**KIRKLEES METROPOLITAN COUNCIL
INVESTMENT & REGENERATION SERVICE**

DELEGATED DECISION TO DETERMINE PLANNING APPLICATIONS

Reference No:	2025/62/90236/E
Site Address:	Dearne Grange Cottage, Park Head Lane, Birds Edge, Huddersfield, HD8 8YA
Description:	Erection of garage incorporating garden store and music room and formation of driveway
Recommending Officer:	Nina Sayers

Officer Report

DRAWING DESCRIPTION
GARAGE SCHEME
EXISTING AND PROPOSED

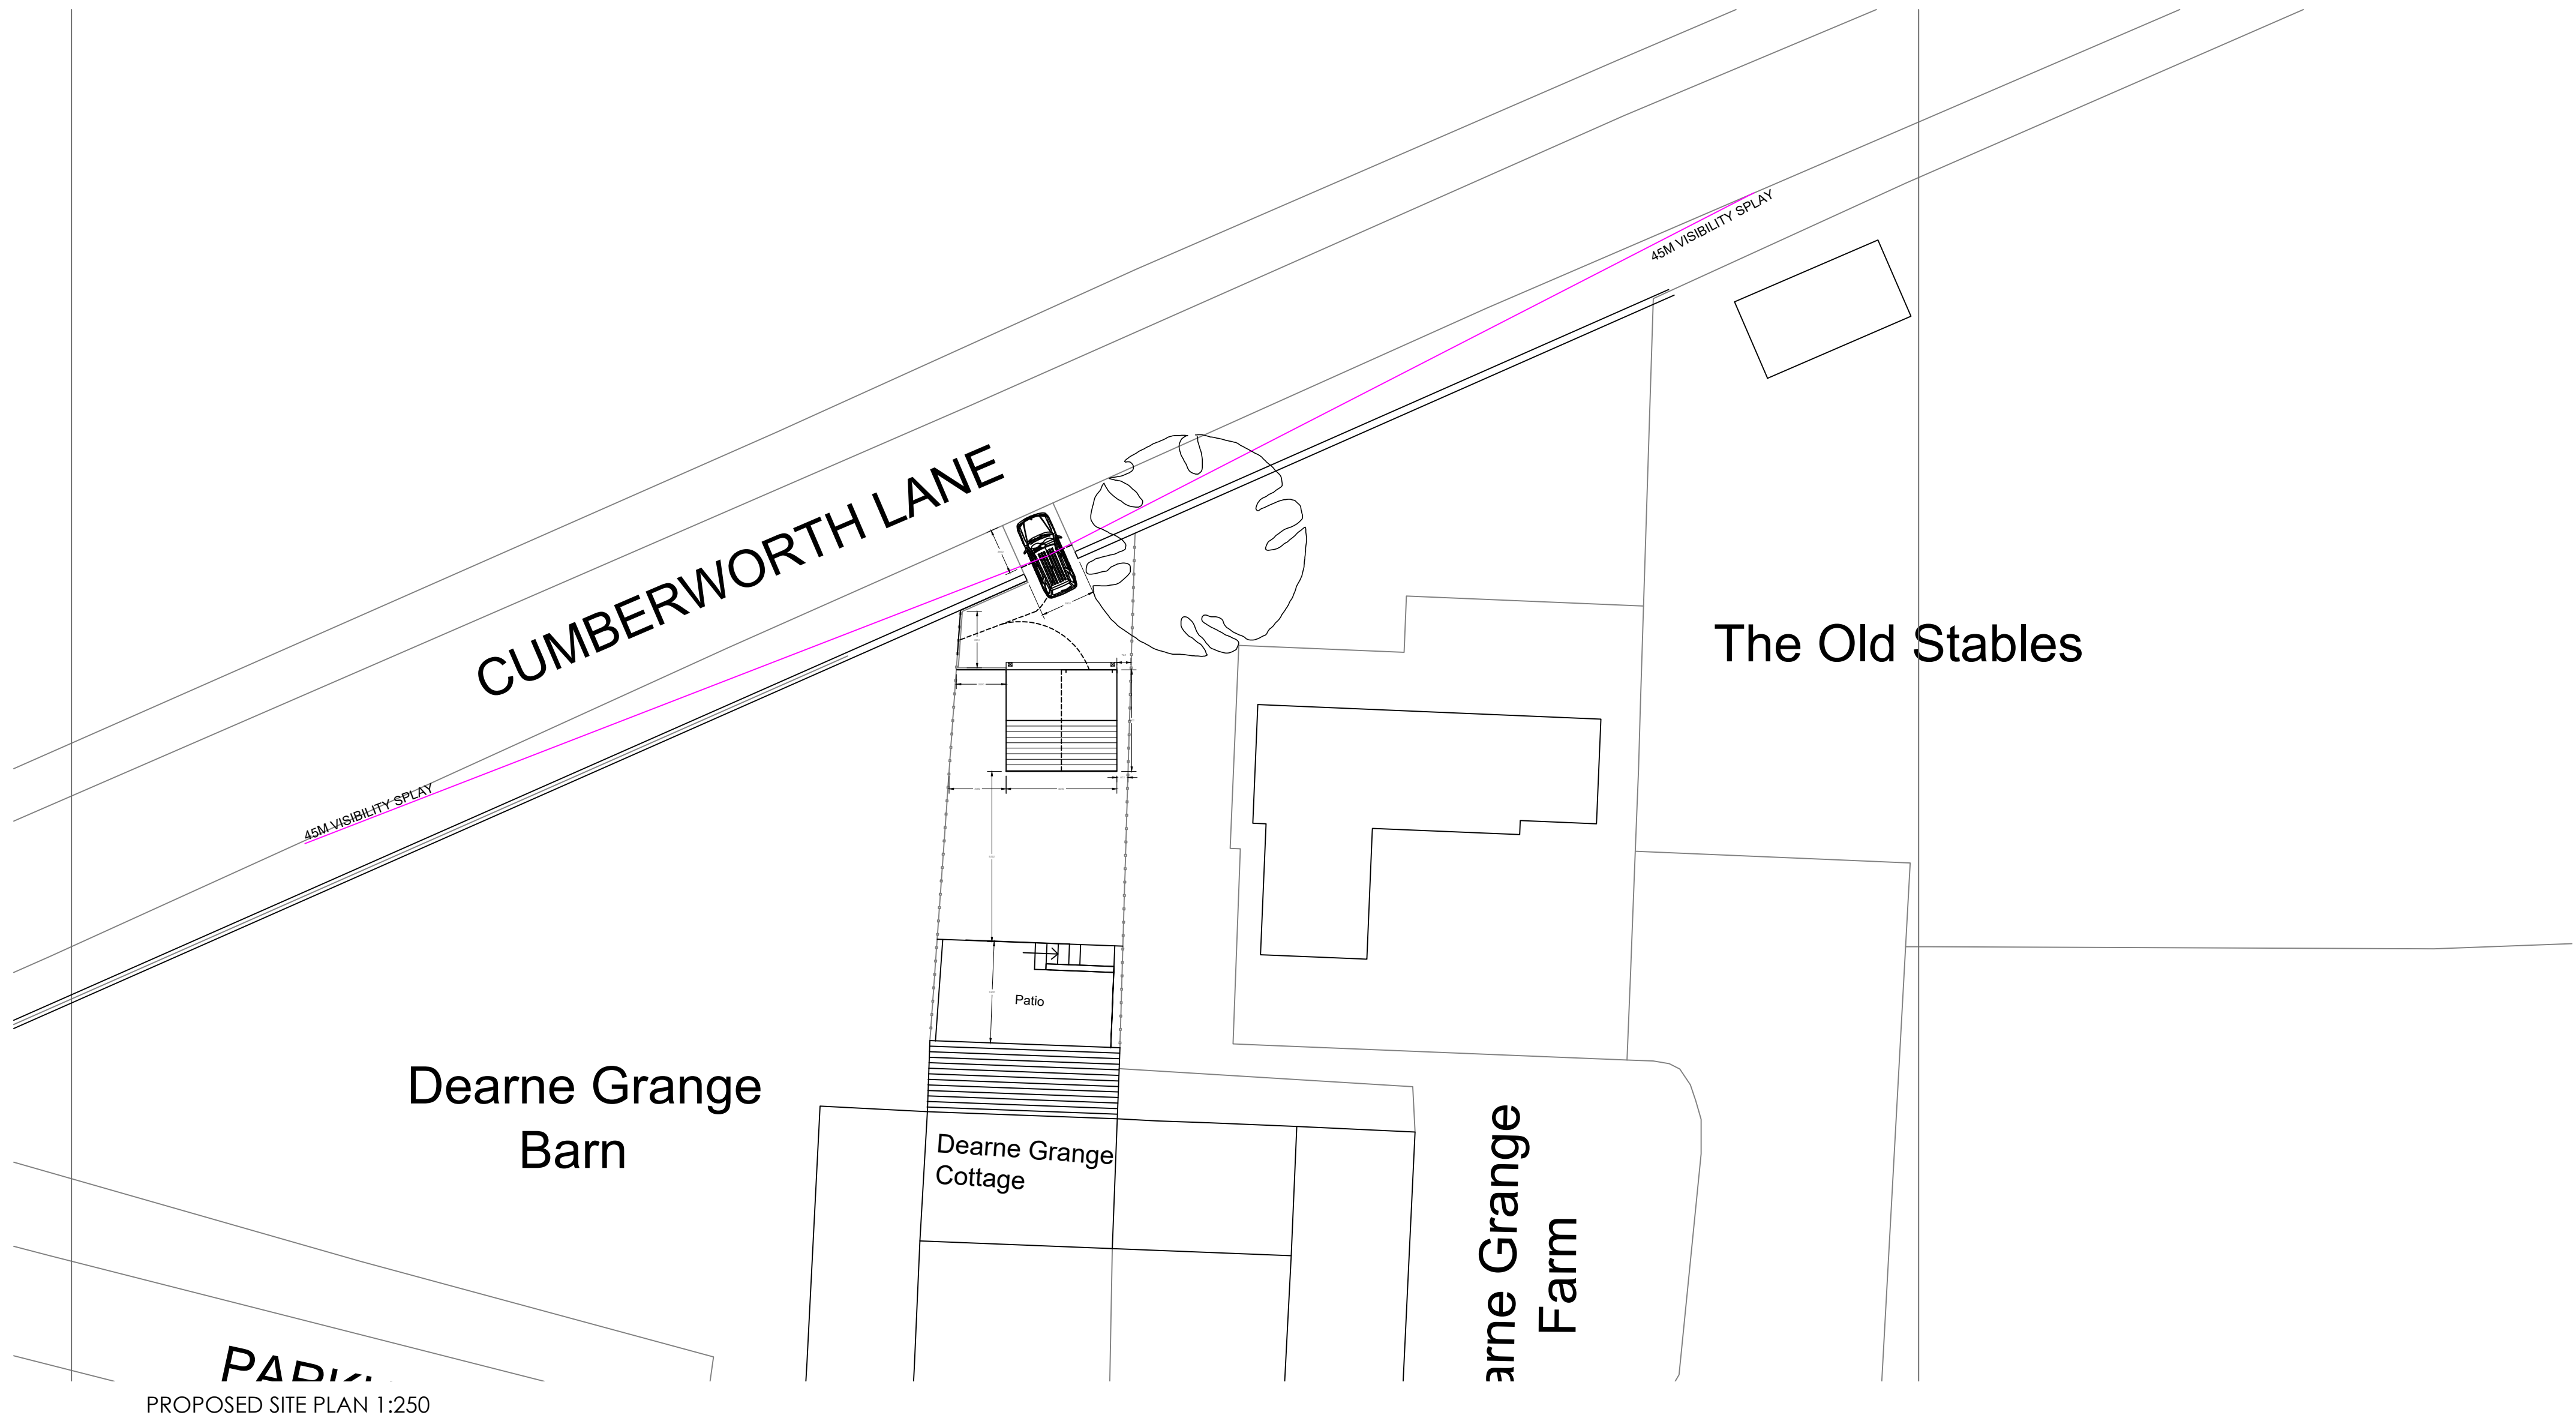
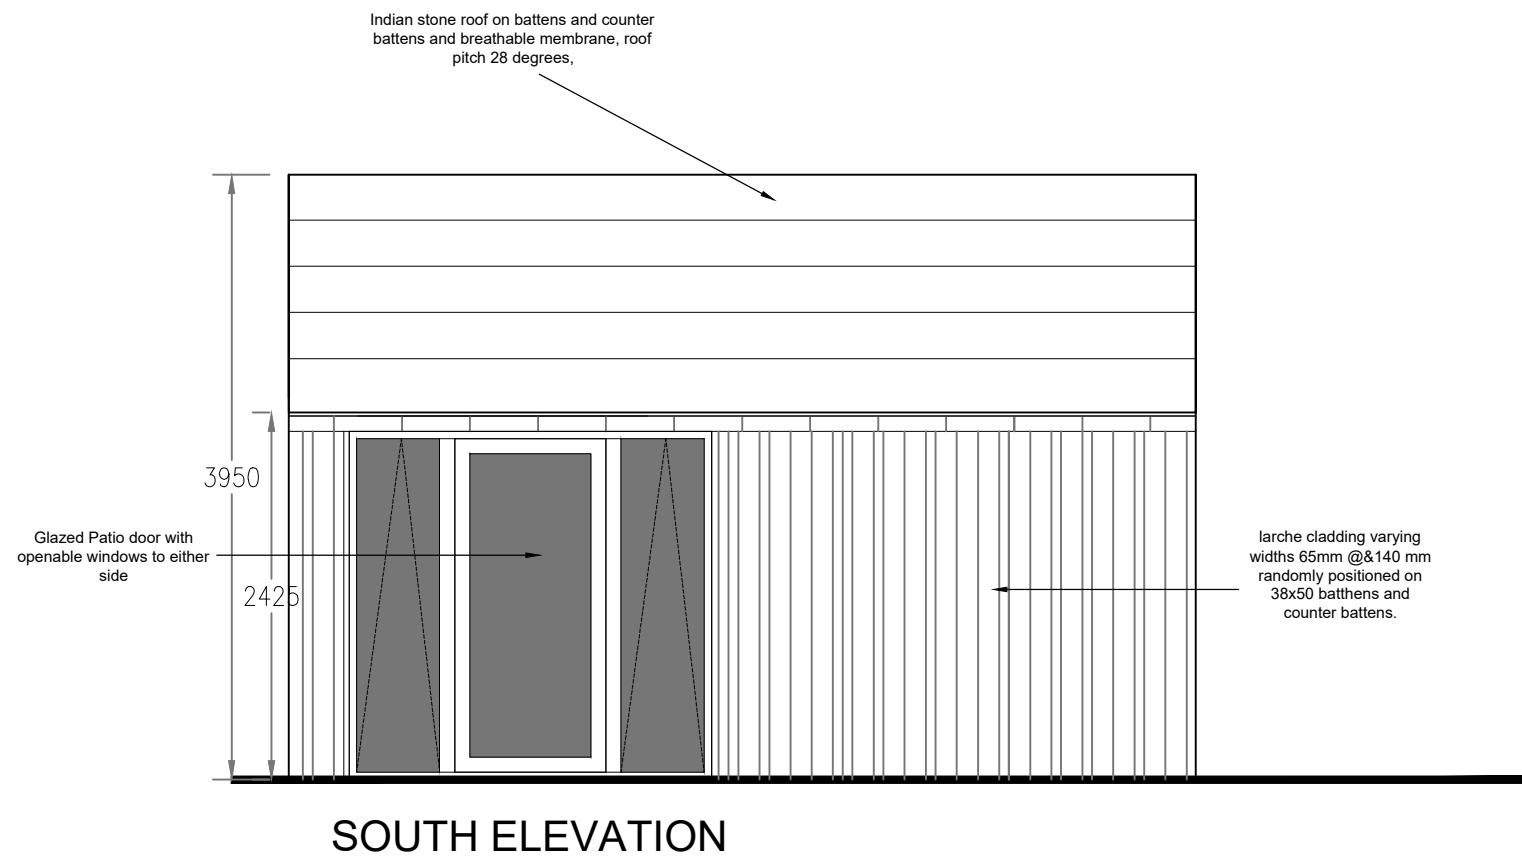
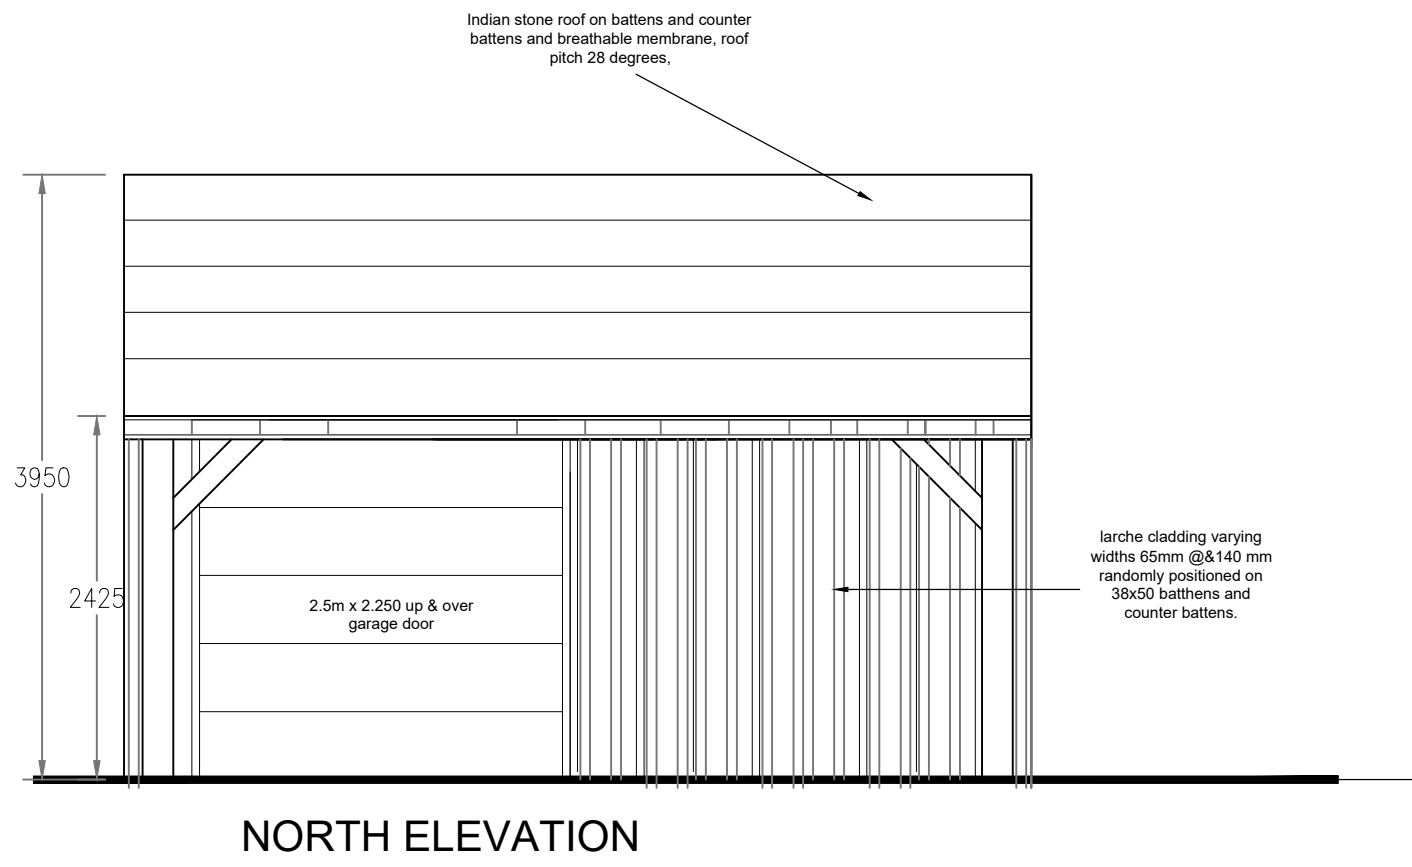
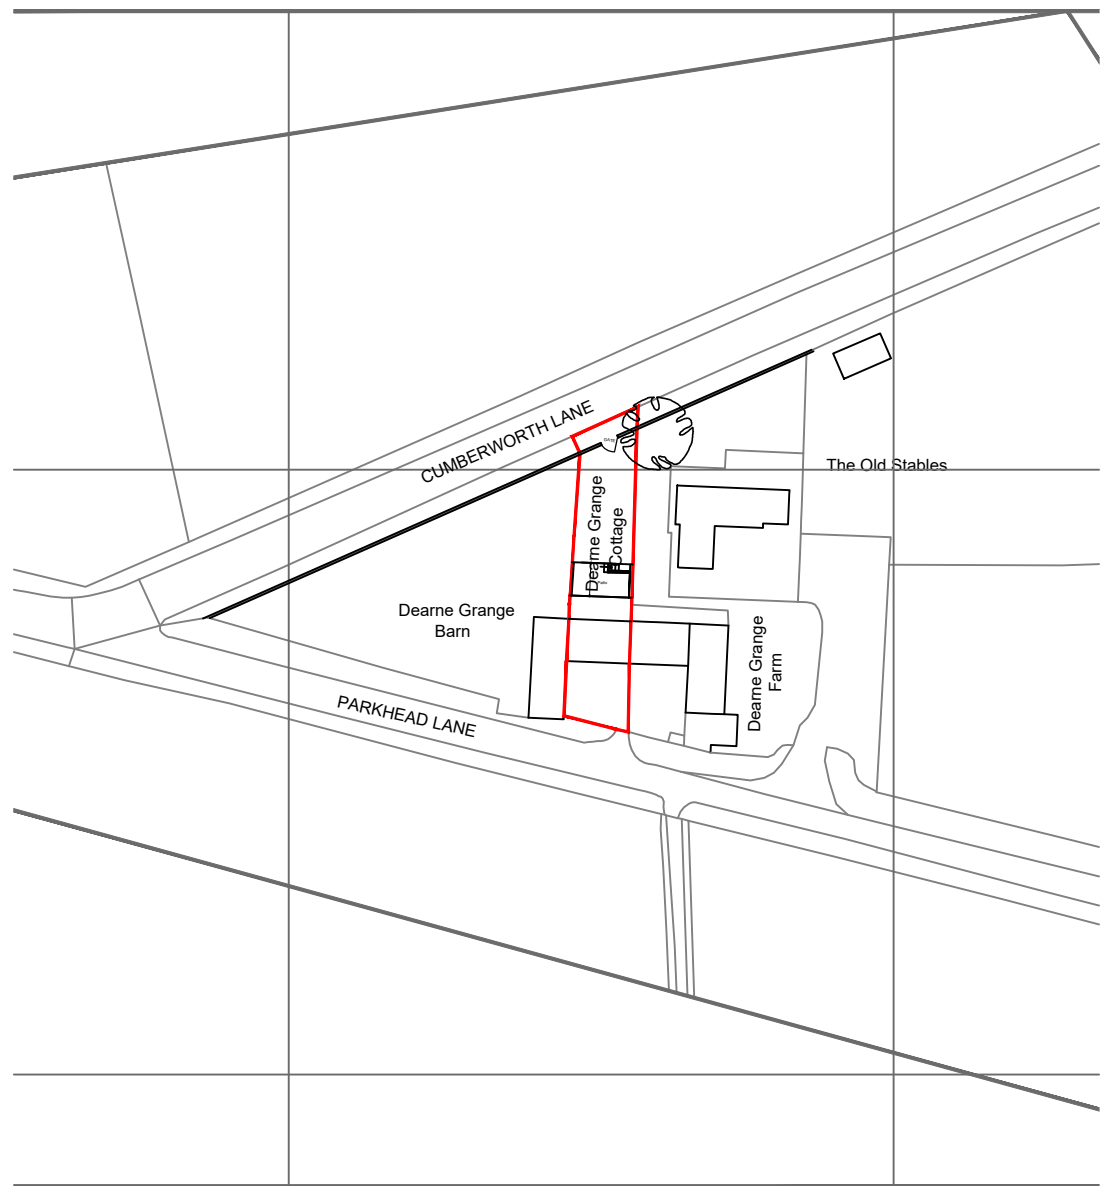
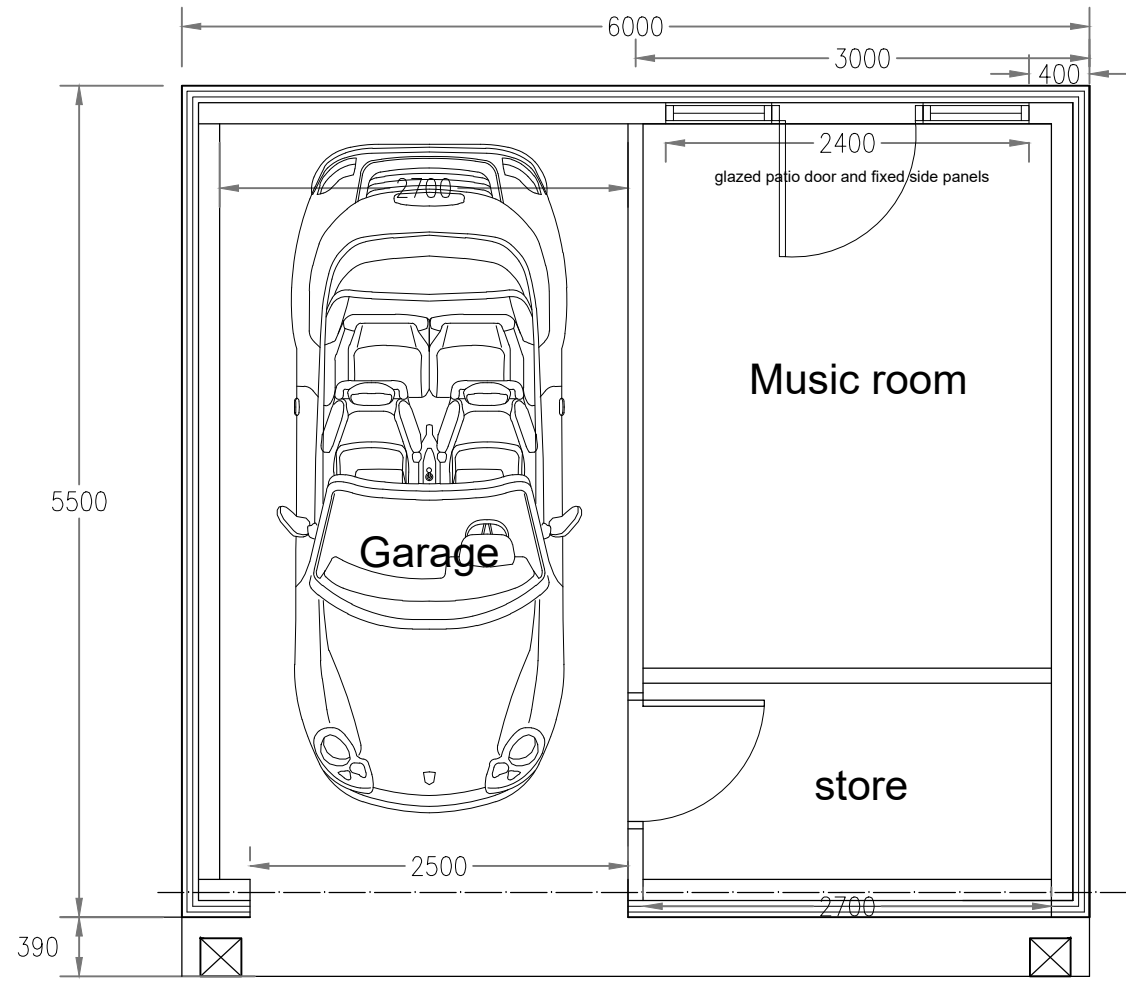
Amendments were sought to show a 6m x 3m internal space in the garage and to demonstrate that the proposal would not protrude above the roof of the house.

Cumberworth Lane, which is not a classified highway, has a 40mph speed restriction adjacent to the site. A visibility splay of 45m is demonstrated on the submitted plans however it is apparent that a visibility splay of ~100m can be achieved which complies with the Highways Design Guide SPD.

The applicant was requested to amend the internal measurements of the proposed garage to 3x6m to comply with requirements for internal car parking spaces.

The proposed outbuilding, when considered cumulatively with the existing extension, would cover a similar footprint to the original dwelling however both additions are single storey and therefore have a lesser volume. This is not including the existing shed which would be removed as part of the proposed development. The additions are therefore considered to be subservient to the host dwelling in terms of size. It is noted that the existing dwelling is set down, at a lower topographical level than the rear garden. Therefore, officers sought clarity from the applicant that the proposal would not protrude above the existing dwelling house roof ridgeline. A section was provided showing the proposed building would be set below the existing dwellings roofline by ~65cm.
